East Anglia One North (EA1N) and East Anglia Two (EA2) Offshore Wind Farms

**Planning Inspectorate Reference: EA1N – EN010077 &
EA2 – EN010078**

Deadline 6 - 24 February 2021

**ESC Comments in Response to the Applicants
Deadline 5 Submissions**

m

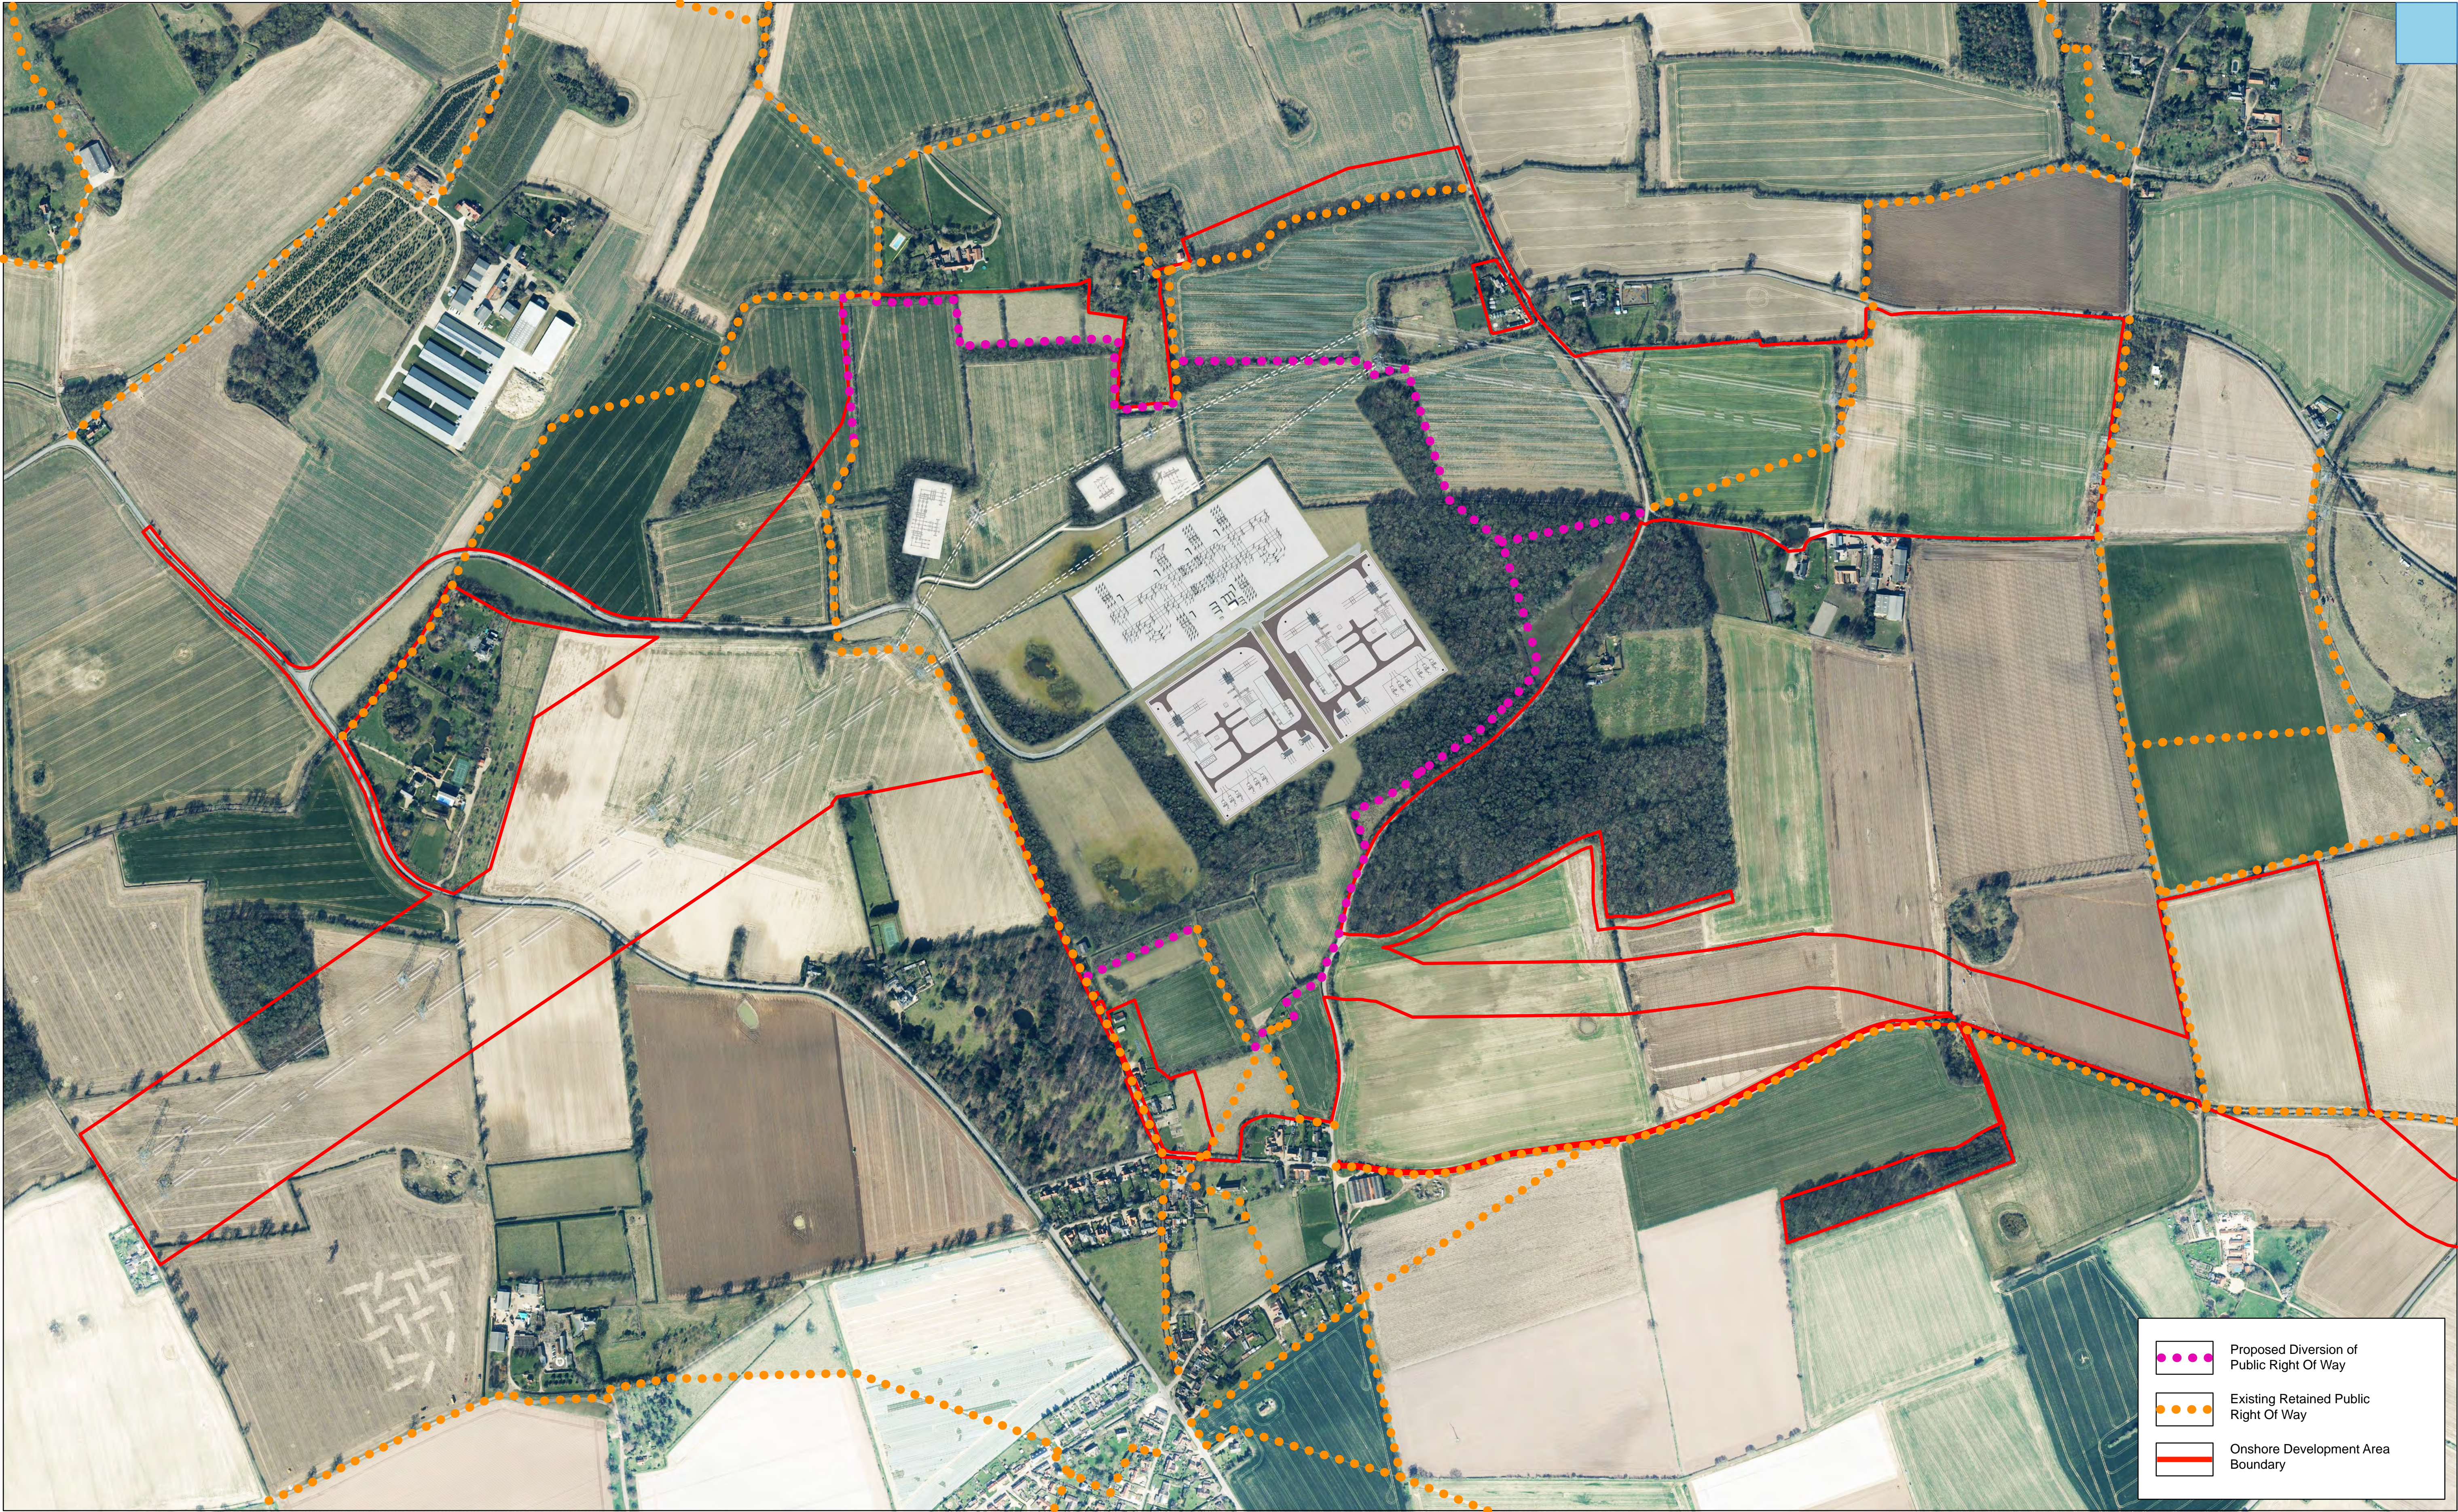
Applicant’s Comments on ESC’s Deadline 2 Submissions (REP5-010)			
<i>Ecological Enhancement Clarification Note (REP1-035)</i>			
9	Table 3 – This table states that 85.59km of new hedgerow planting will be provided at the substations. This figure appears excessive as the Outline Landscape Mitigation Plan (OLMP) General Arrangement drawing (ref. 29.11a) only appears to show approximately 5km of new hedgerow planting. Further clarification in relation to this matter is required.	The Applicants have identified that the existing hedgerow length at the onshore substation locations is 3.68km. The calculations in the Ecological Enhancement Clarification Note (REP1-035) assume that 3.68km will be removed as a result of construction of the Projects. The Applicants note that there is likely to be a calculation error in the length of newly planted hedgerow at the onshore substation location. This will be reviewed, and an update provided at Deadline 6.	Noted. We will provide further comment when the updated information is available.
